From: Amanda Scholes on behalf of Planning.Responses
Sent: 08 February 2018 08:39
To: Planning.Scanning
Subject: FW: LU/7/18/DOC - Land adjacent to Shell Garage, Worthing Road, Littlehampton - Condition 4, SW Drainage

From: Paul Cann
Sent: 07 February 2018 14:19
To: Ross Leal
Subject: RE: LU/7/18/DOC - Land adjacent to Shell Garage, Worthing Road, Littlehampton - Condition 4, SW Drainage

I note the percolation rate and can confirm that soakaways are not feasible as a complete solution.

Engineering Layout

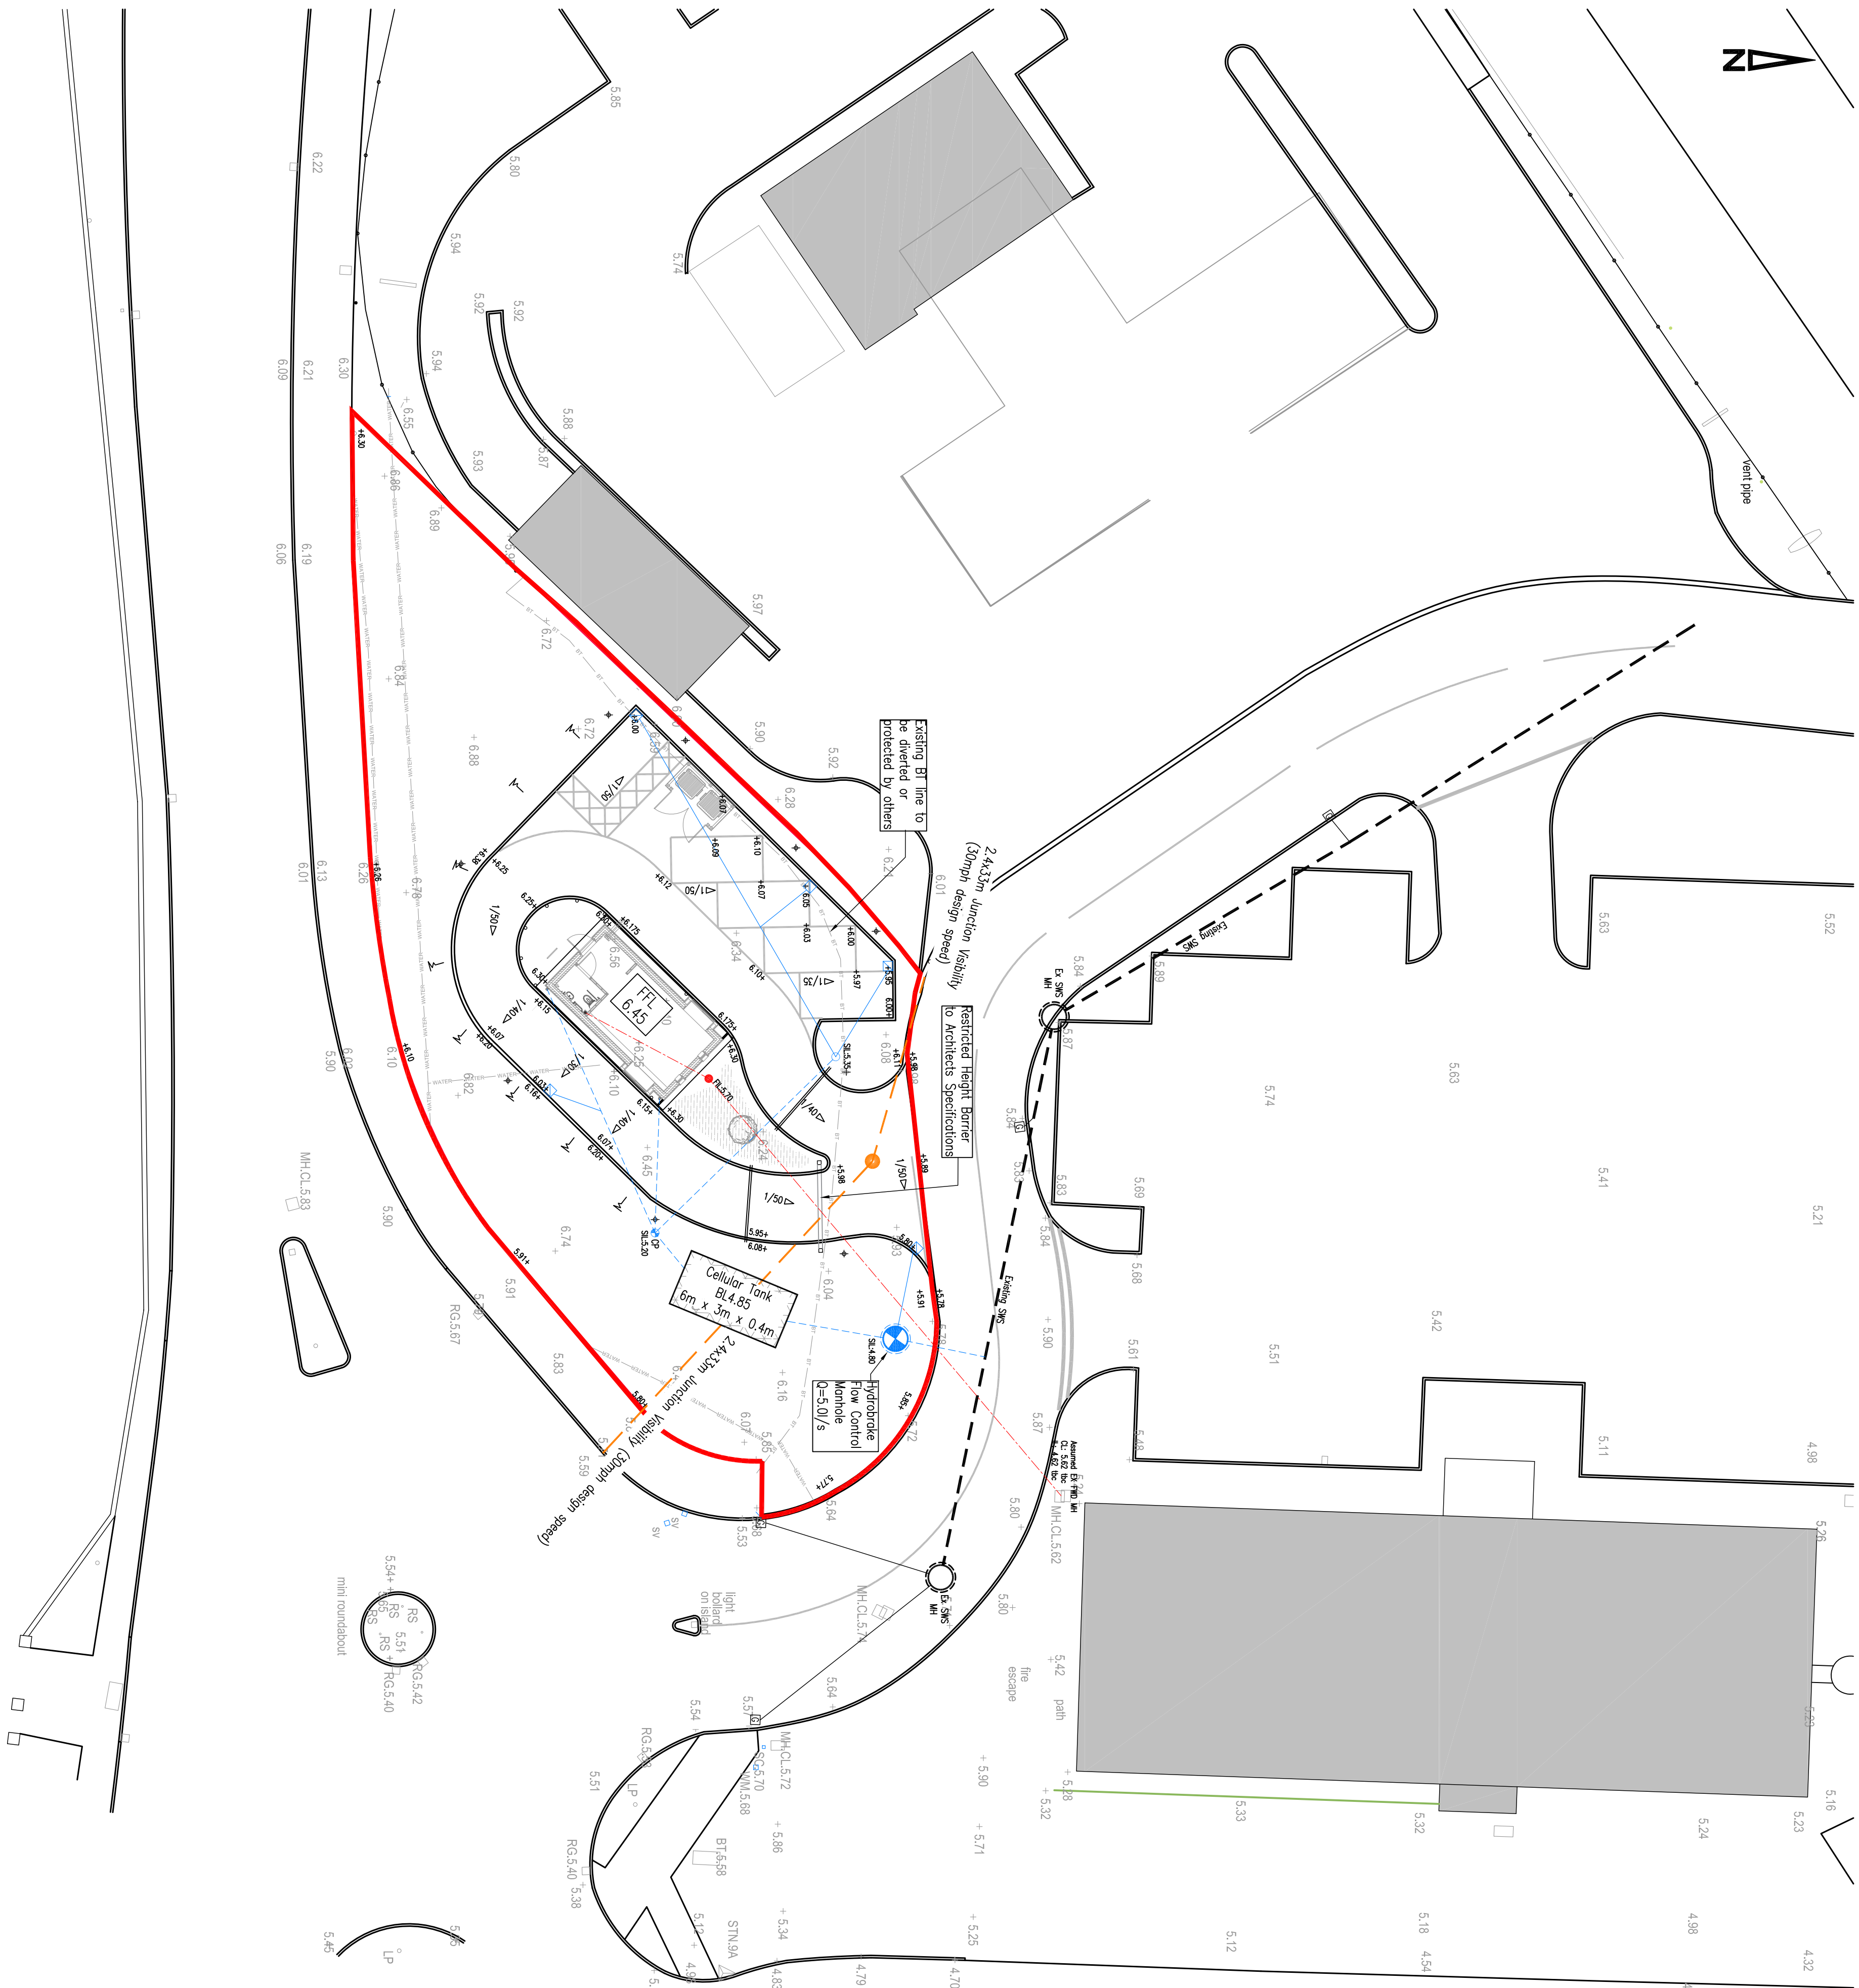
1. Confirm where the existing surface water drainage system discharges too. Presumably, this is the 'bodyshop' lake?
2. Specify more details of the existing pipe being connected to ie. diameter/levels.

4. Specify inlet and outlet levels for storage tank and incoming pipe diameter.
5. Tank outlet pipe diameter – increase to 150mm.
6. Provide catchpit manhole details.

TYPICAL CELULAR TANK SECTION
(TO BE INSTALLED IN ACCORDANCE WITH MANUFACTURERS INSTRUCTIONS)
SCALE NTS

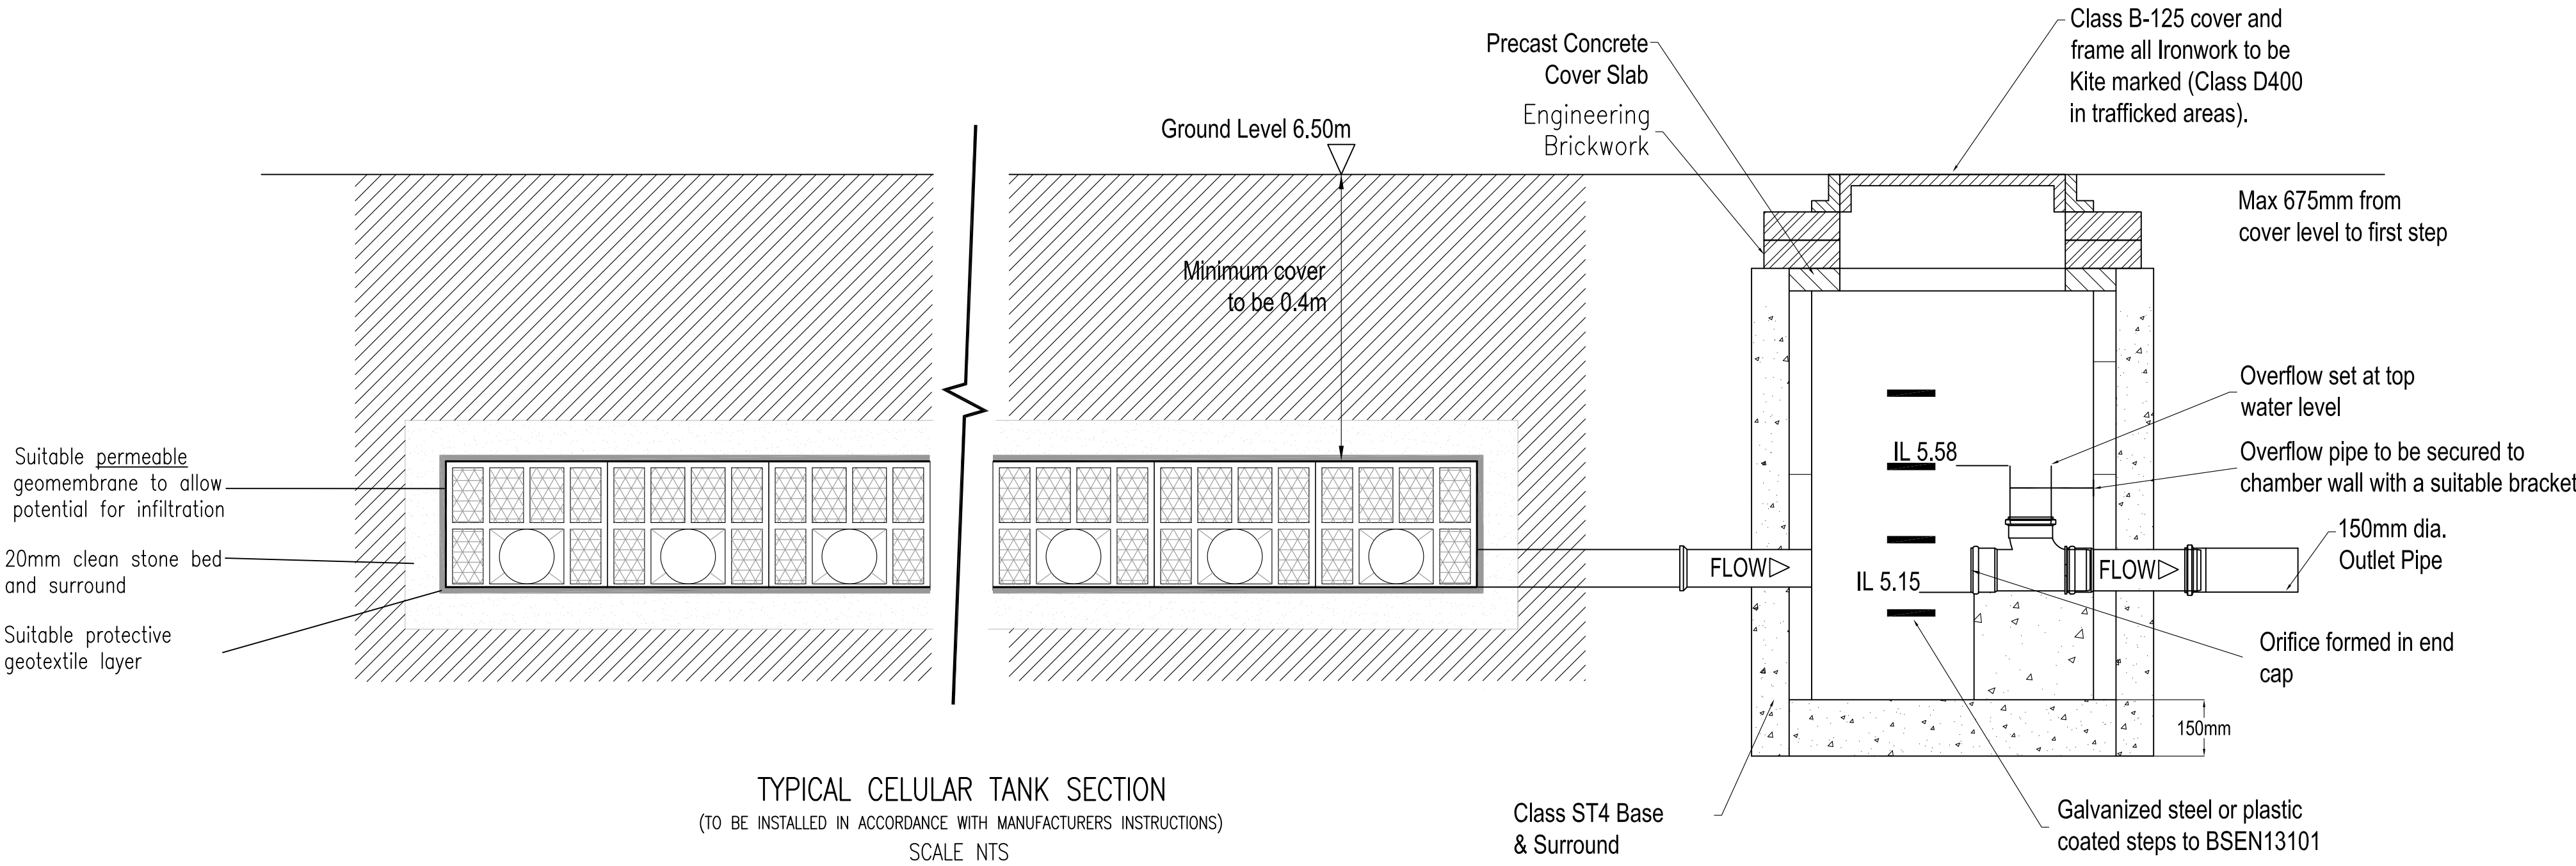
10. Whilst infiltration is negligible, specify a permeable geotextile membrane wrapping to the crates to make use of any potential infiltration. The current coarse sand surround should be replaced with larger granular material ie. 20mm clean stone.

Typical Orifice Flow Control Manhole
Scale N.T.S.

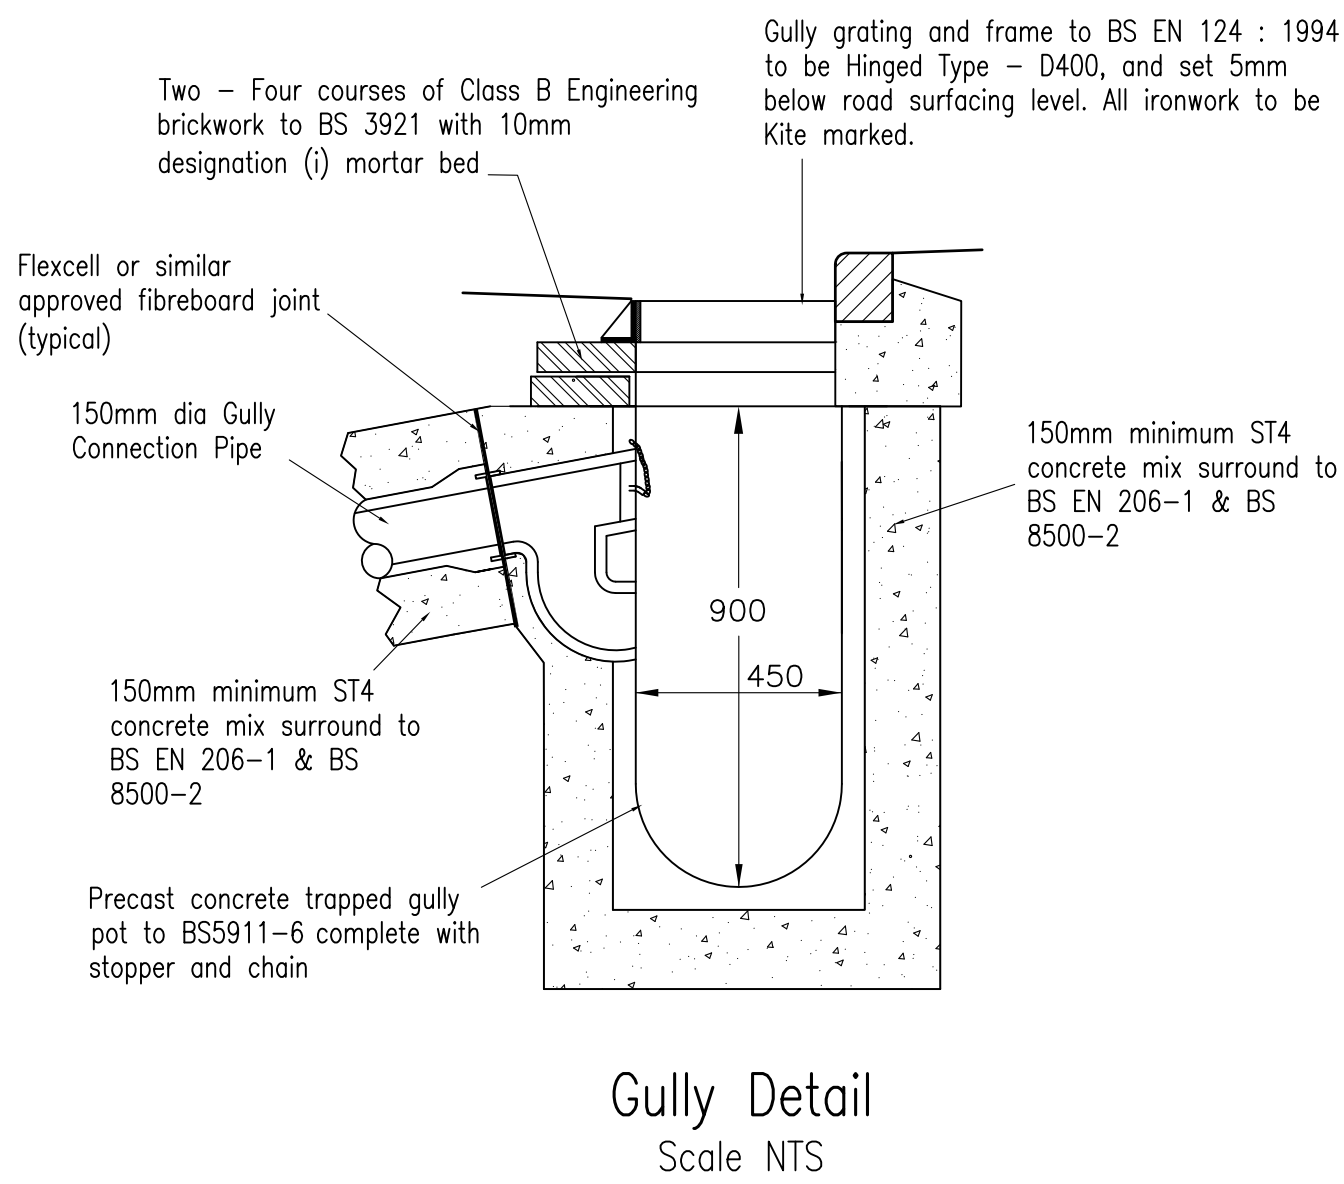
7. Provide hydrobrake technical details from manufacturer.
8. Hydrobrake manhole to incorporate step rungs and bypass door/wire.
9. Microdrainage calculations are required to prove that the 1 in 100 year storm event + 30% allowance for climate change can be accommodated within the system.
